WAYNFLETE LOWER SCHOOL - ADDENDUM #4 [post bid]

date: Friday, March 31, 2017
project: Waynflete Lower School Addition & Renovations, 2013-0050
prepared by: Austin Smith Scott Simons Architects
to: Cordelia Pitman Wright Ryan Construction
Rick Bergeron Wright Ryan Construction
Luke Dione Wright Ryan Construction
Anne Hagstrom Waynflete School
Patrick Boure Waynflete School
Phil LaClaire PML Project Management

Subject: Addendum #4 to Bid Documents of January 12, 2017

A525

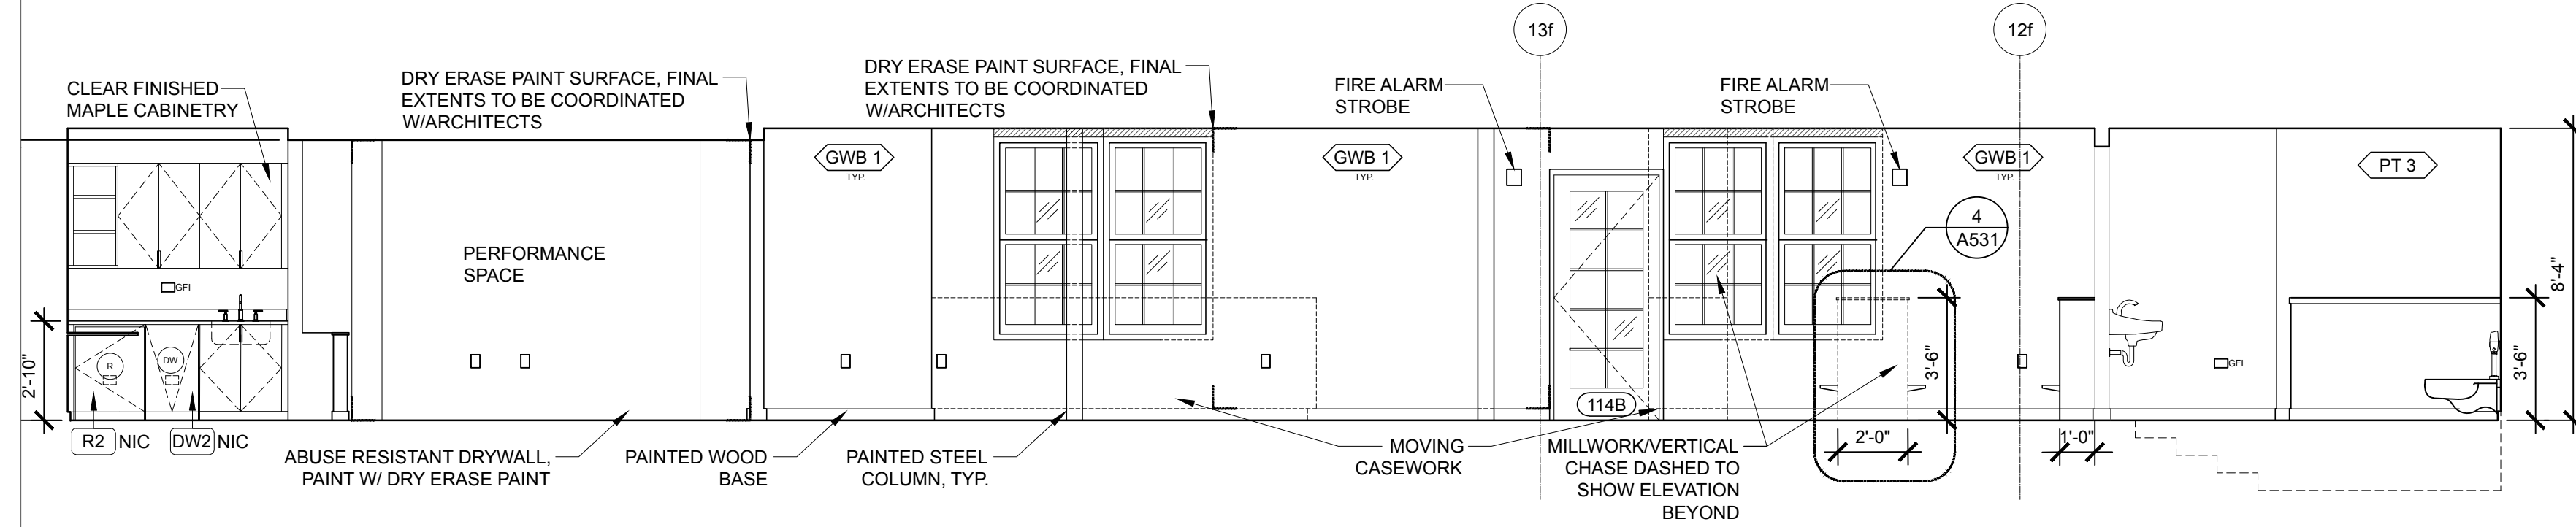
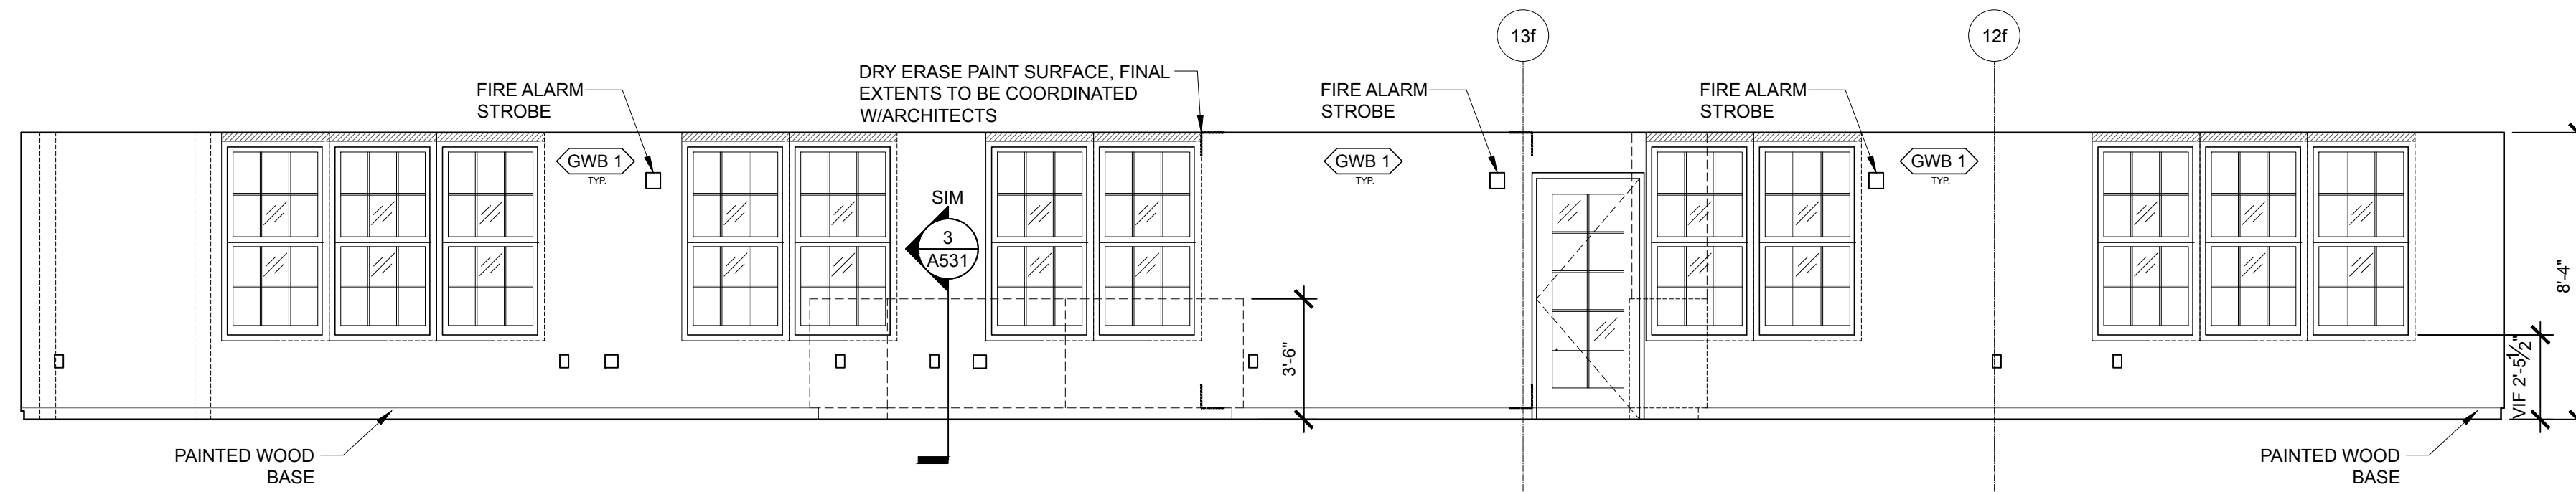
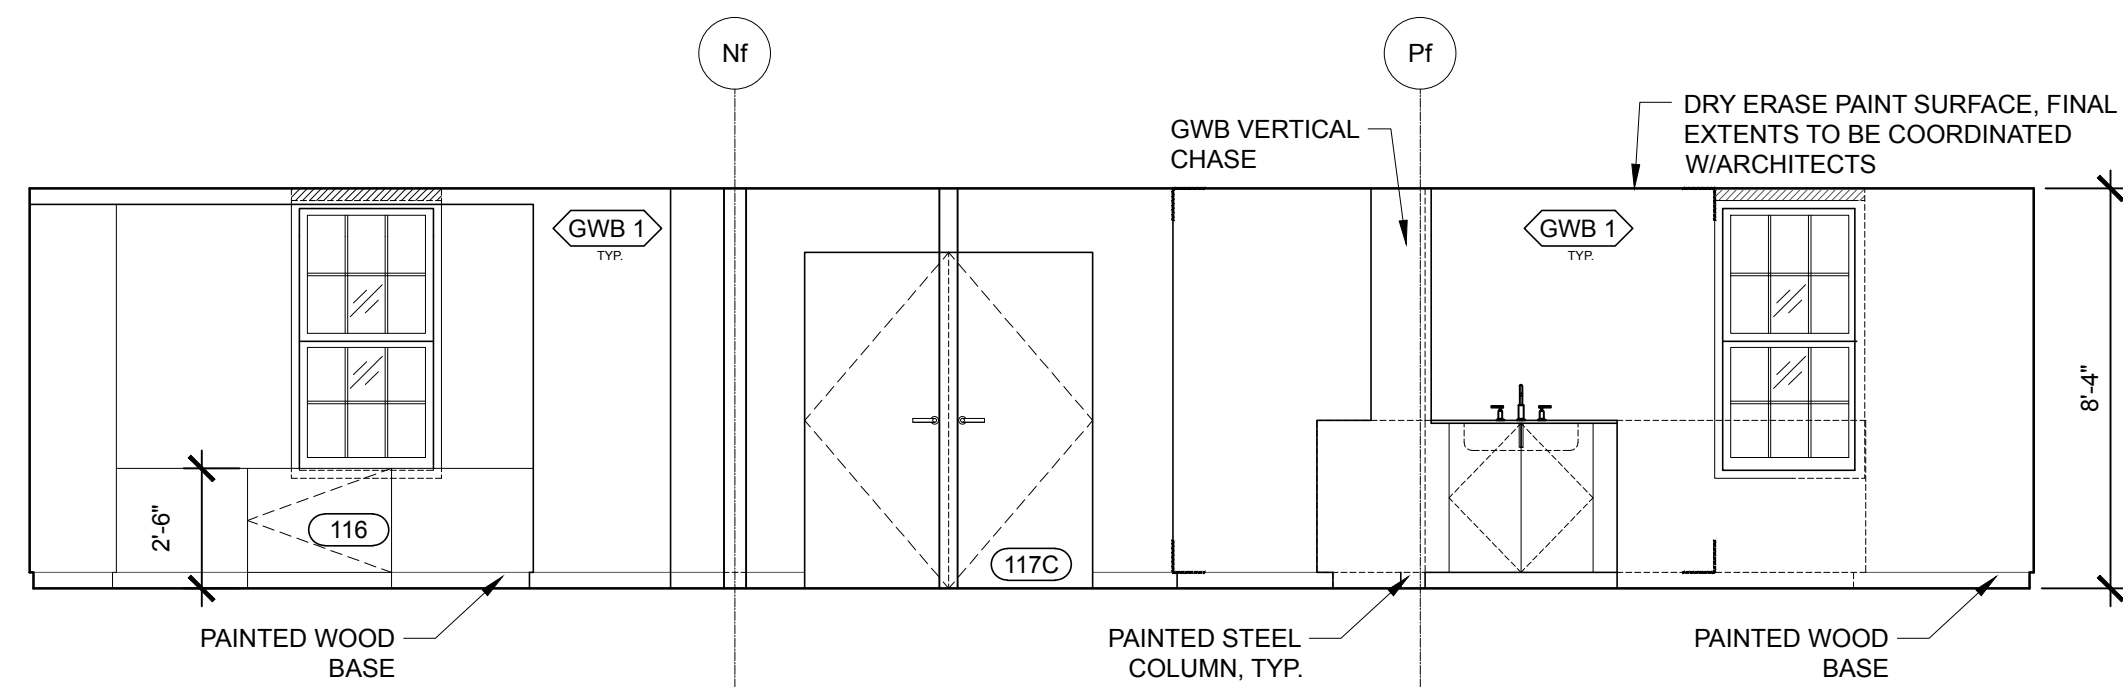
- 4-D1 Sheet A131 At "Exterior GWB Soffit" Note:
Add: ": Provide level 5 finish skim-coat over sheathing, typical. Provide V-groove vinyl trim at control joints"
- 4-D2 Sheets A523,
A525
A536
A528 At classroom interior elevations all instances of this note:
Delete: "Dry erase paint surface, final extents to be coordinated w/ architects"
- 4-D3 Sheet A601 Under General Notes related to the Door and Frame Schedule:
Add: "5. All paired doors with combination 3'/2' doors, the 2' leaf shall be inactive with use of egress hardware"
